EAST PRESTON PARISH COUNCIL

Re: Planning Application EP/158/19/HH – The Breakers, 29 Tamarisk Way, East Preston, BN16 2TE

1:100 North elevation (front) as existing

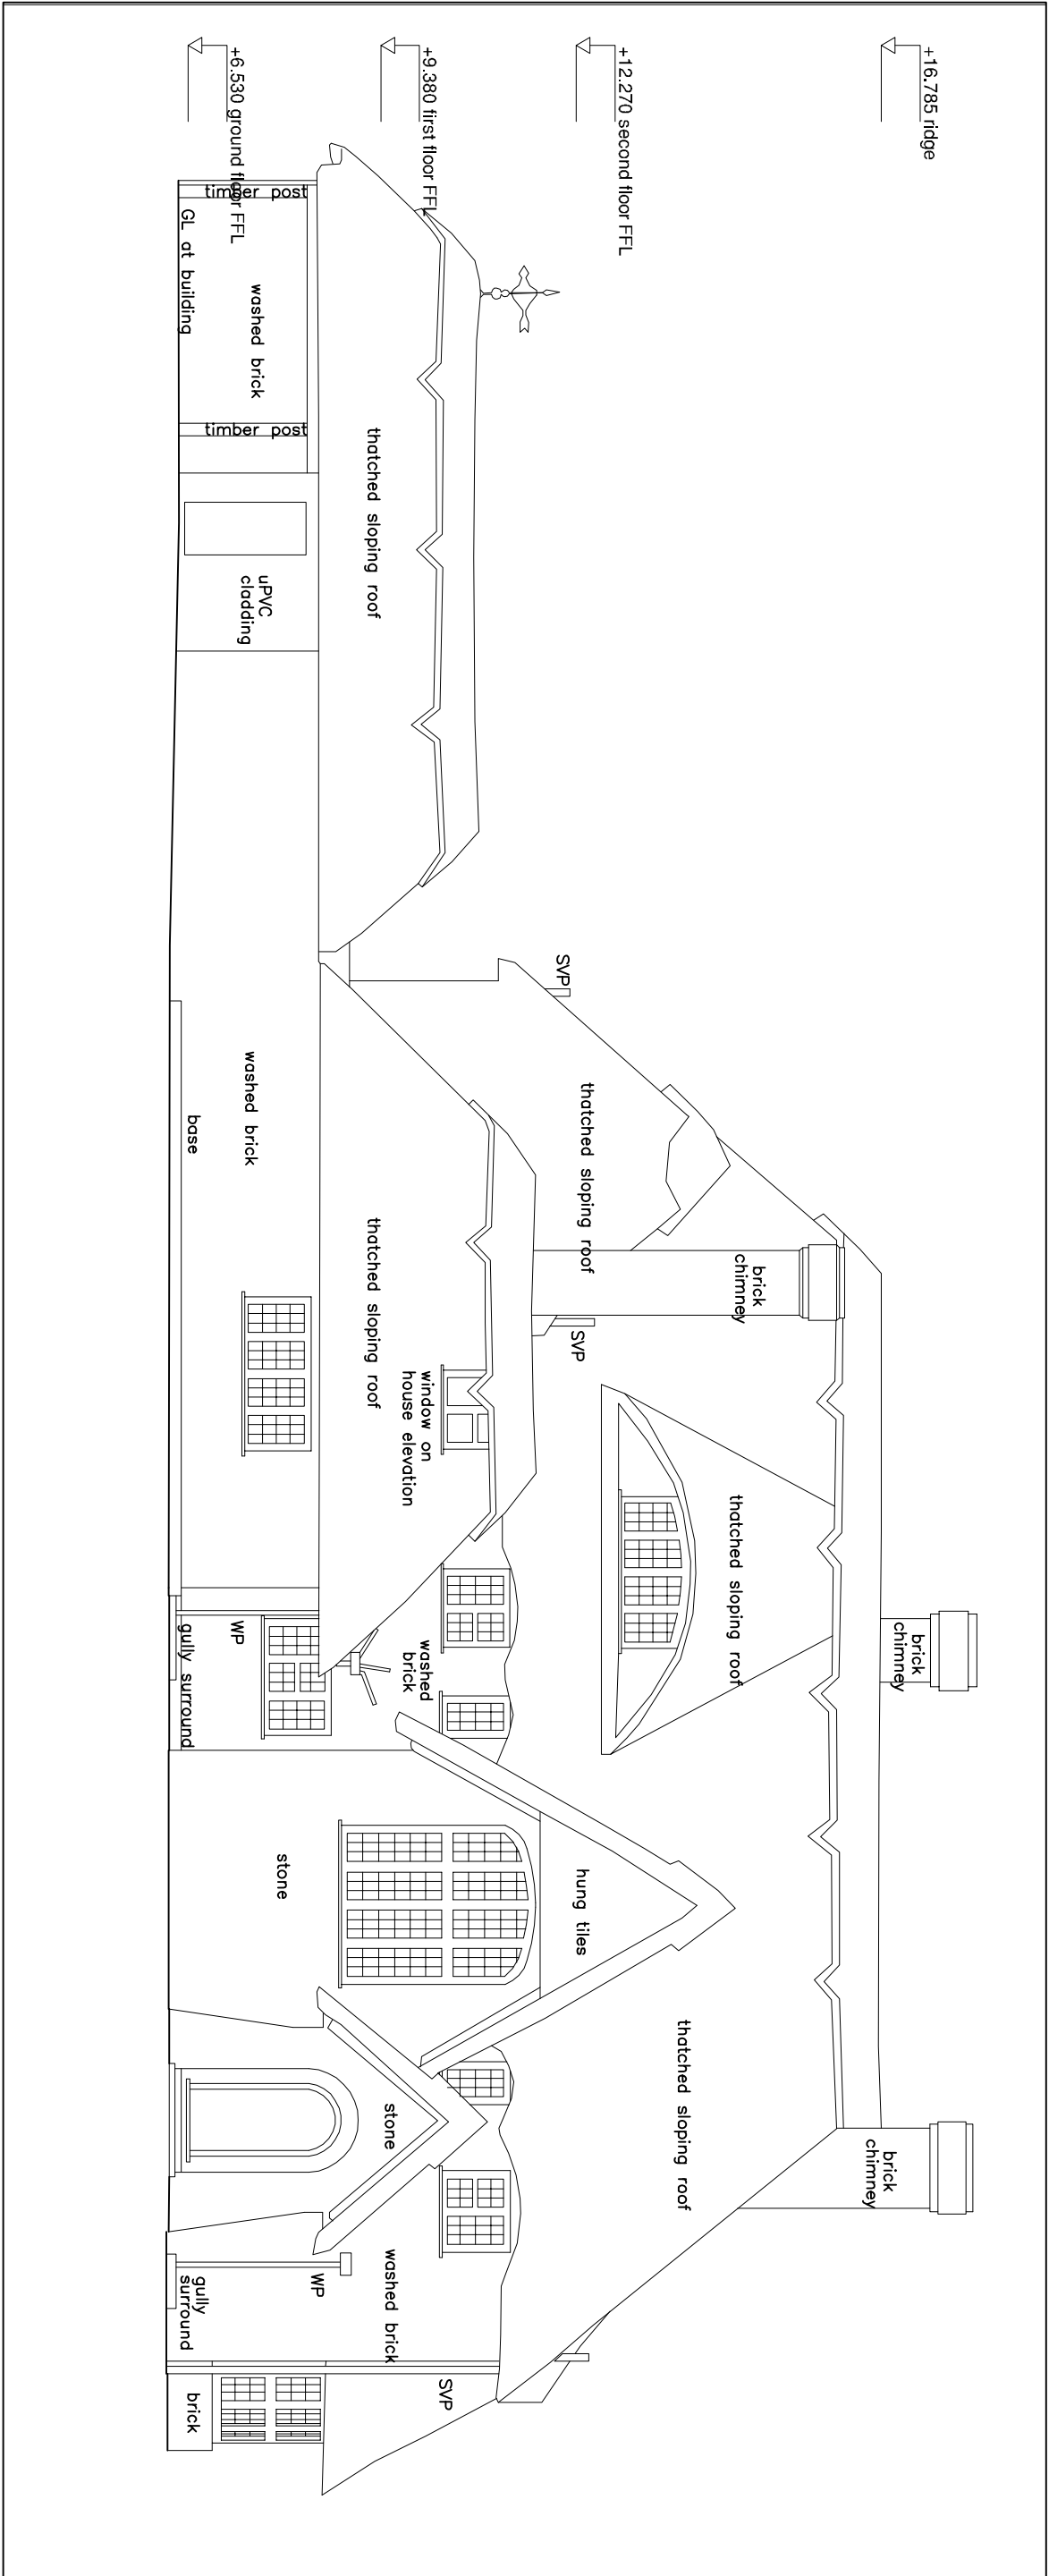
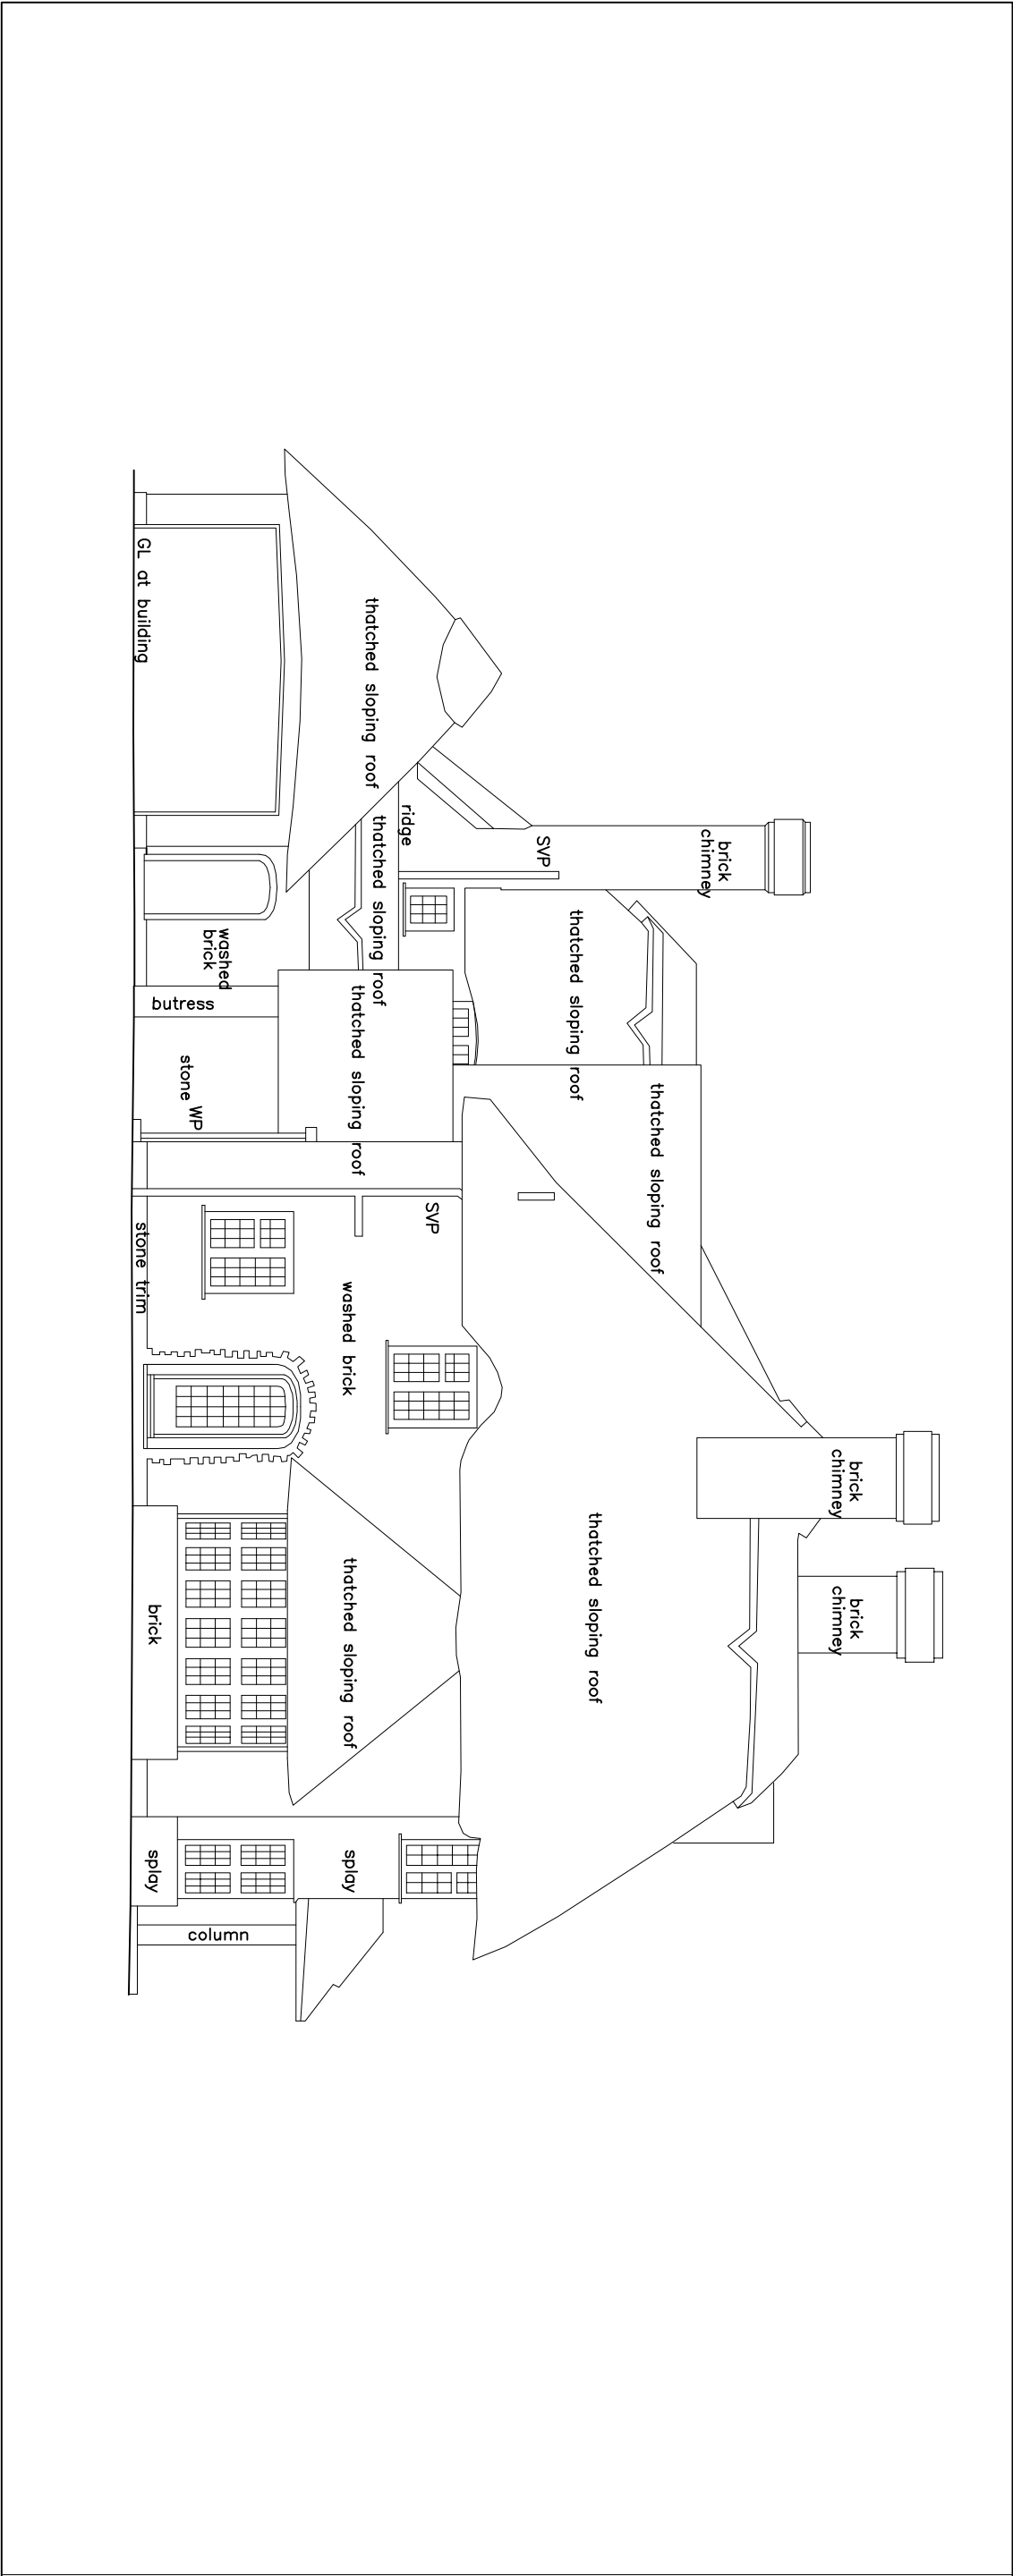
The existing northern boundary wall is very characterful and pretty in its design, unique in the locality. The proposed new boundary wall will be out of keeping with the existing property, neighbouring properties and the general feel of the Willowhayne private estate. It is contrary to section 4.26 of the East Preston Neighbourhood Plan which states, "the construction of high front walls or fences should be resisted."
